# New Single Family

Applicant: W.A. One - owner  
 Divulsified Property - Applicant  
 Address: 1670 Forest Ave. - Lane Ave.

Date: 8/19/14

## CHECK-LIST AGAINST ZONING ORDINANCE

**SITE AND UTILITY PLAN**  
1"=10'

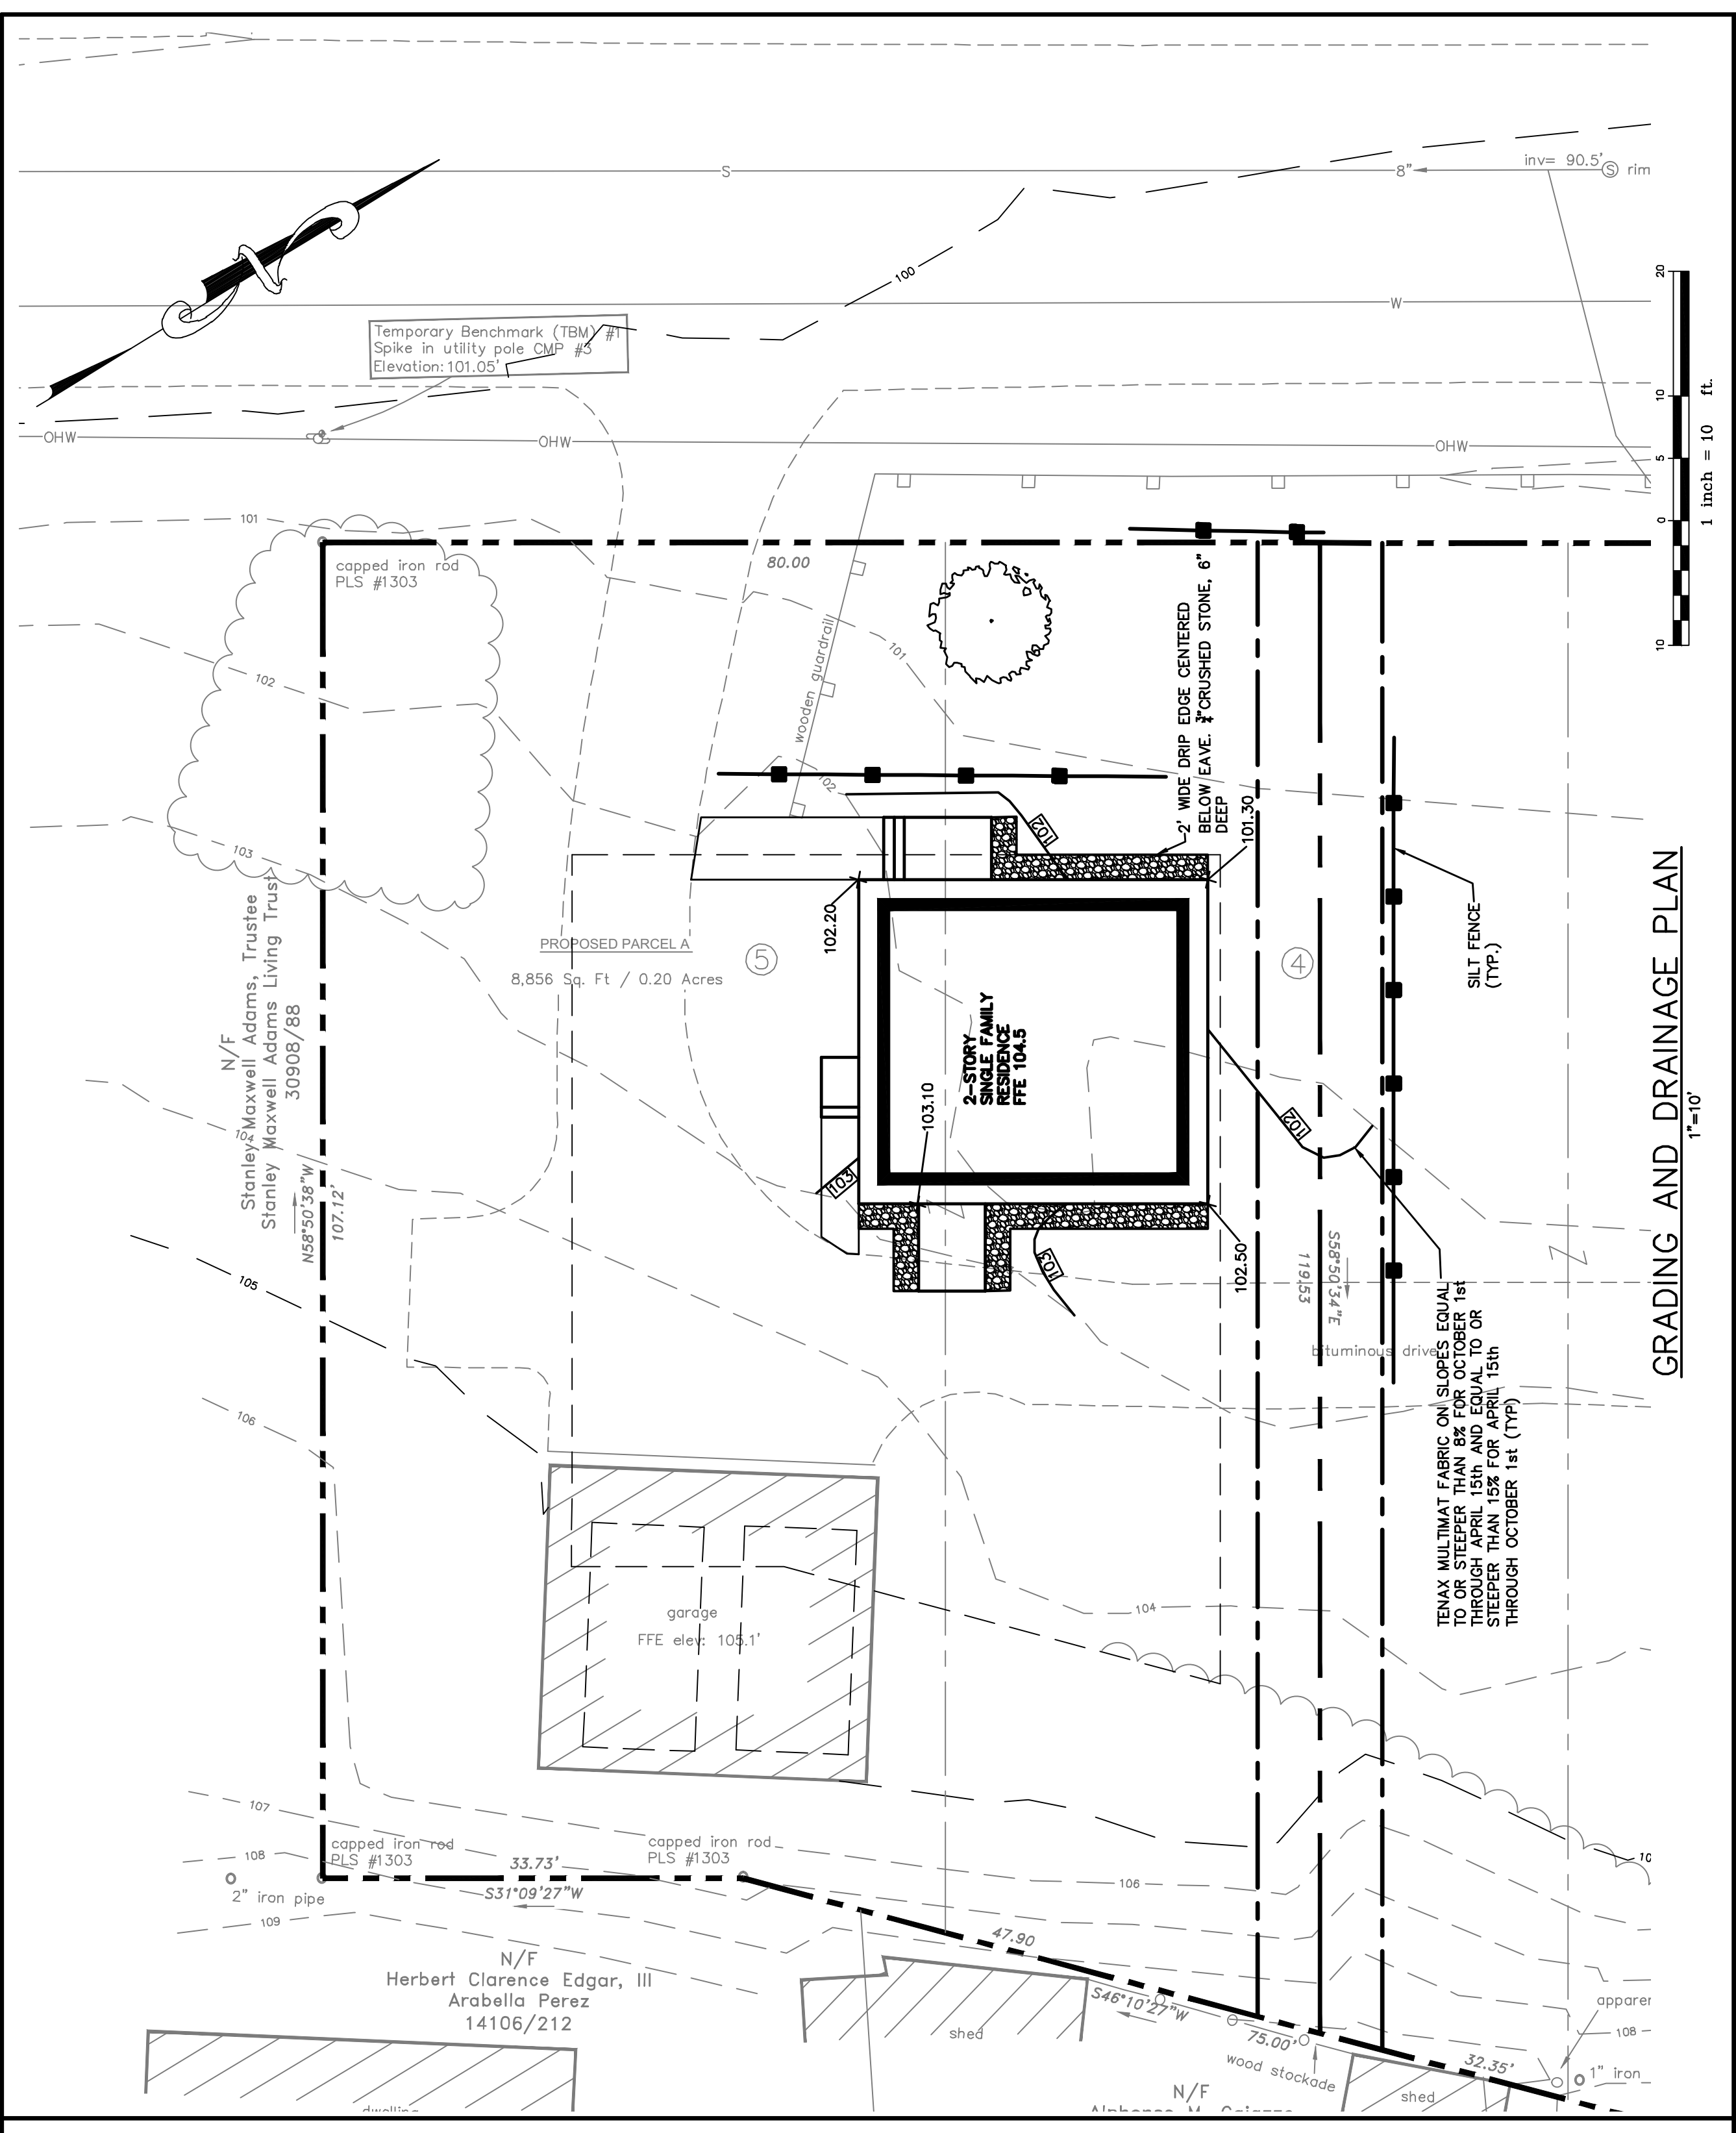
Date - ~~house lot~~ New - land split from 1670 Forest  
 garage existing

existing garage  
 - 8' off new rear.  
 (coltside)  
 - 35' 35.21' on left  
 - 17' on right.

Front Yard - 25' min - 22' scaled to porch - OK using section 14-425.  
 - 27' scaled to house.

Rear Yard - 25' min - 50.5' scaled to bulkhead (OK)

Side Yard - 2 strips - 14' min - 9' on left - ok can borrow from right - need 28'  
 1st strip - 8' min 39' on right. from land. has 48' total

Projections - front porch 5' x 8.6', bulkhead 7' x 4.33' (doghouse), - side entry (left)  
~~4.9 x 4.33~~ 4.9 x 4.33

Width of Lot - 65' min - 80' scaled (OK)

Lot Area - 6500 sq ft min - 8876 sq ft given (OK)

Lot Coverage Impervious Surface - 31% = 3099.6 sq ft
